#### CITY OF ALBUQUERQUE PLANNING DEPARTMENT January 11, 2012 DRB Comments

PROJECT # 1002588

RE: Portions of Lots 1 - 6, Blocks 1 & 2, Manchester Place Addition

LOTS A, B & C IDEN-SAMORA COMPOUND

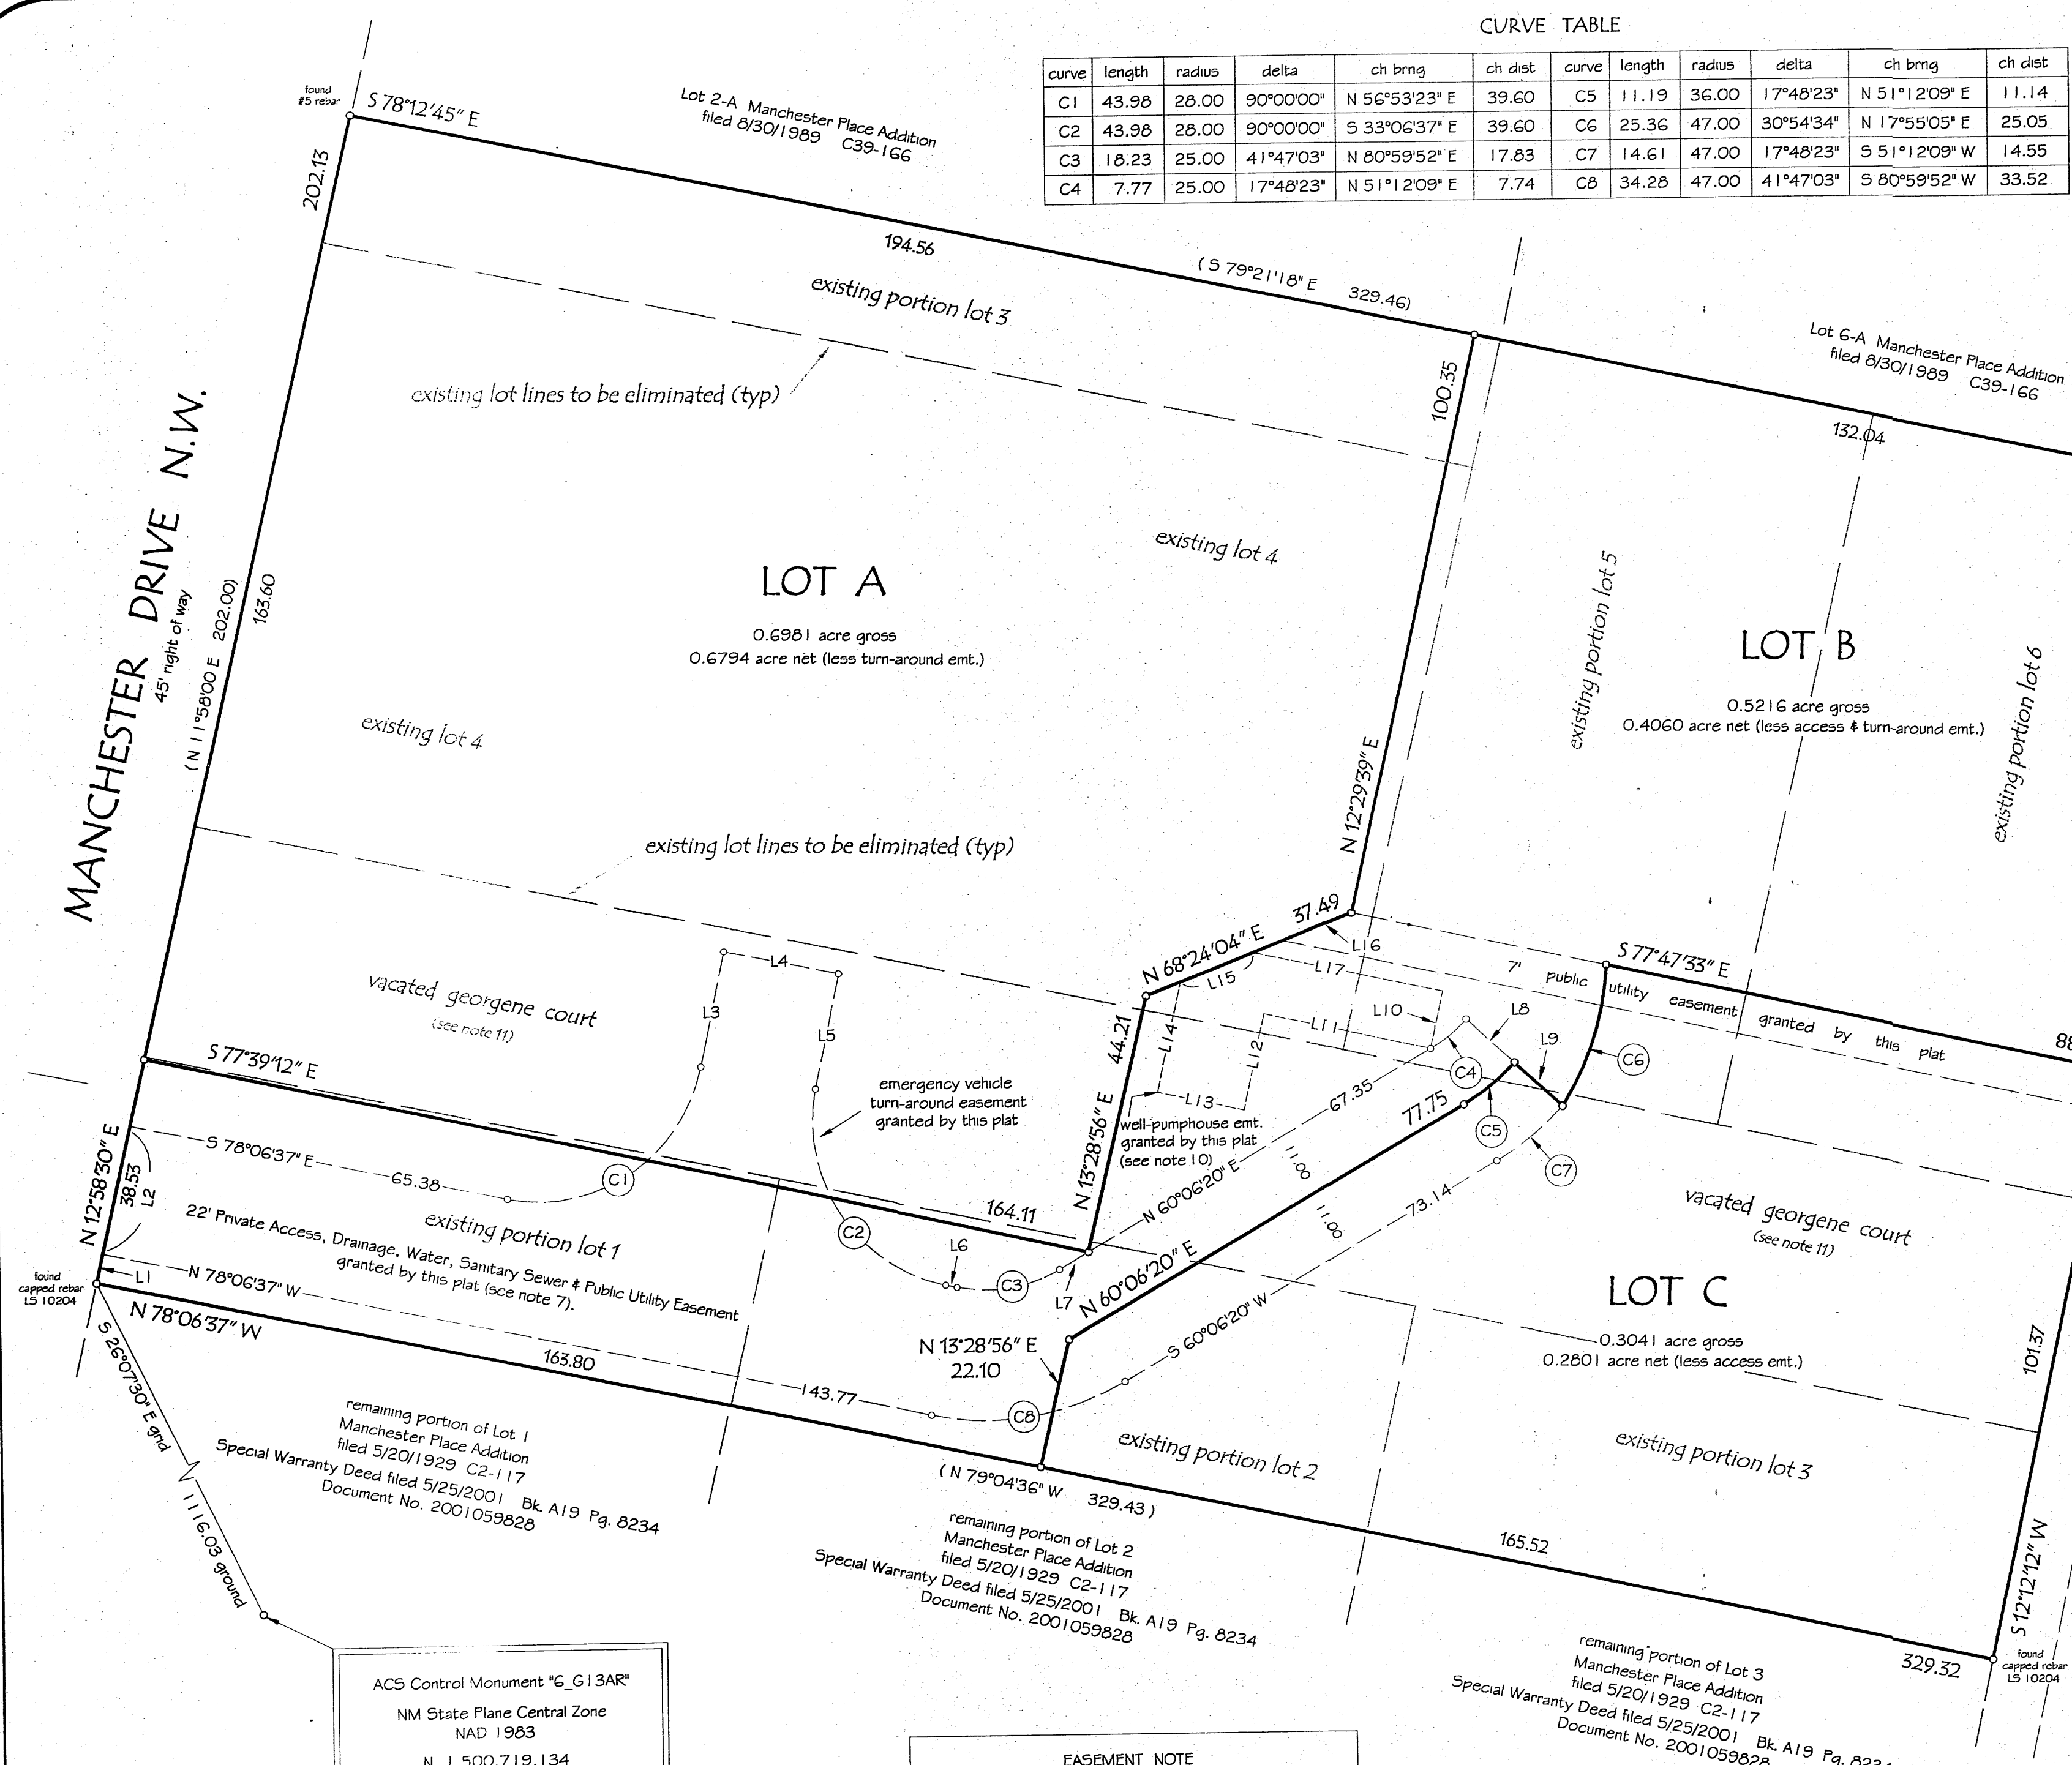
APS Development Agreement needs to be recorded prior to final plat. The 'notch between proposed Lots B and C (line L9 and curve C6) does not appear appropriate – a more uniform boundary should be provided by extending the property line from the end of curve C5 up to the north side of the 7' public utility easement. Setback lines do not need to be shown on final plat.
